TO: APMI, Inc.  
FROM: Sergio Lozoya, Planner  
City of Albuquerque Planning Department  
TEL: (505) 924-3935  
RE: Site Plan Amendment – Coors and Central

I am the Staff Planner reviewing your application for a Minor Amendment for project Z-86-24-1, a Site Plan EPC for a shopping center.

1 EXST SOUTH COLORED ELEVATION
SCALE: 1/4" = 1'-0"

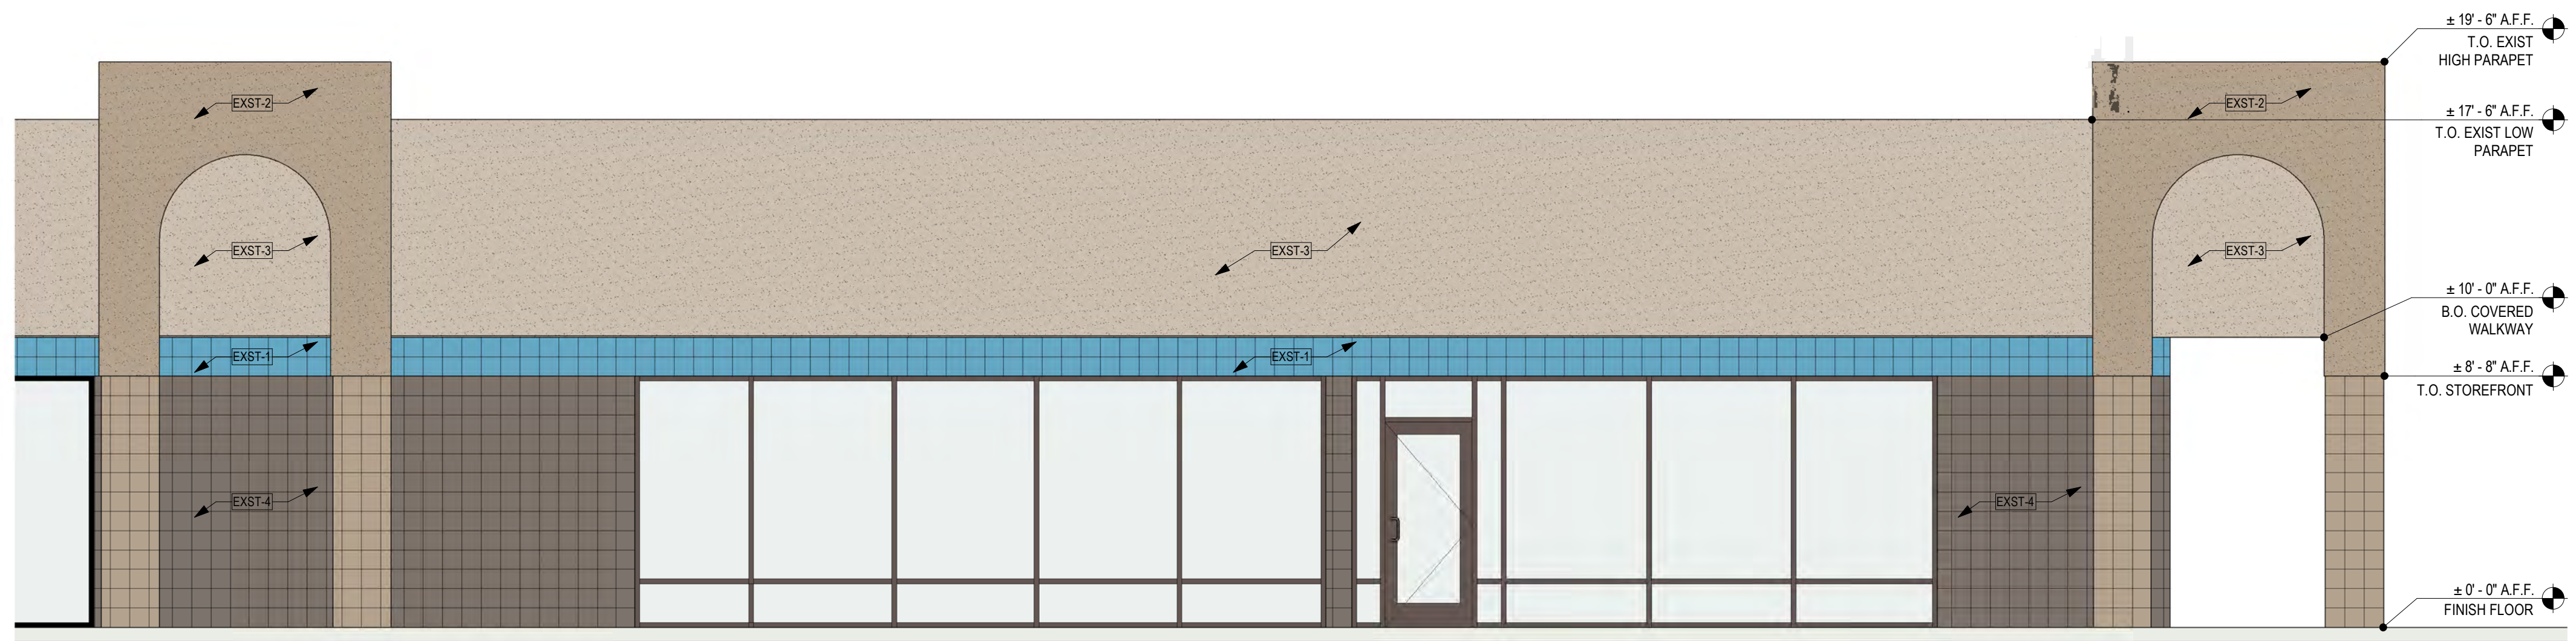
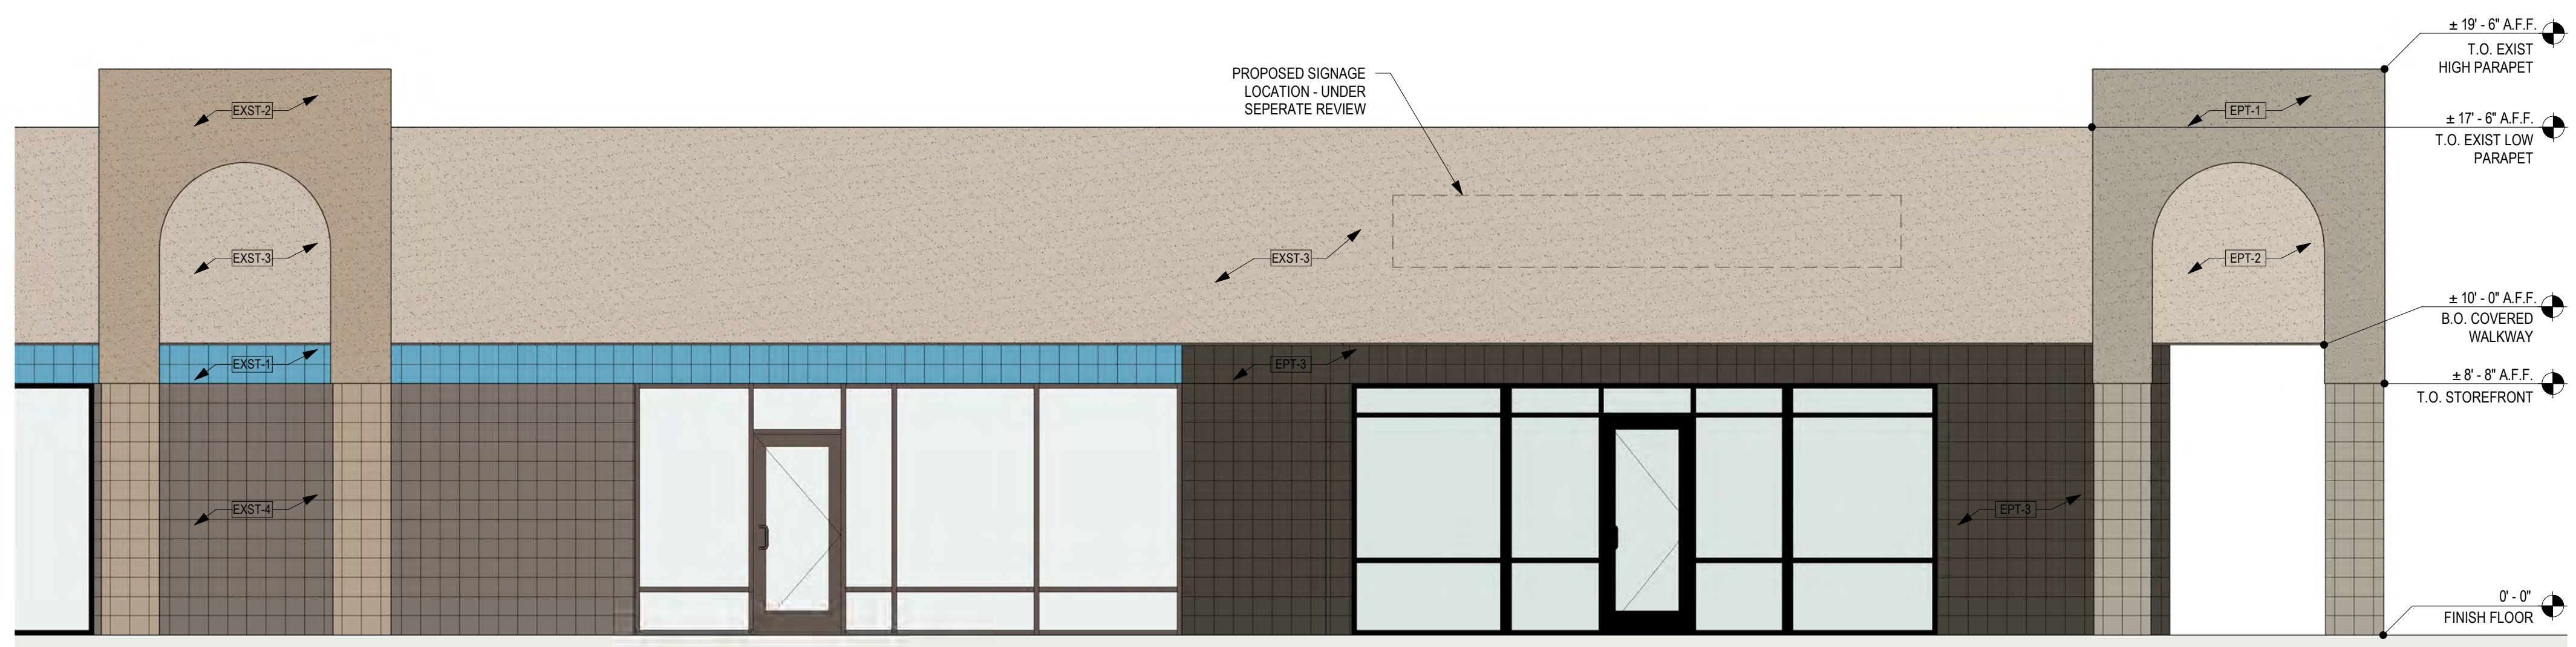
Please summarize all changes in the justification letter, and include all relevant calculations (e.g., parking required/vs. parking provided). Some changes that were not discussed were: the façade improvements, i.e., removing windows, building the entrance tower, reduction in parking (demonstrate total existing vs proposed amount), and new signage.
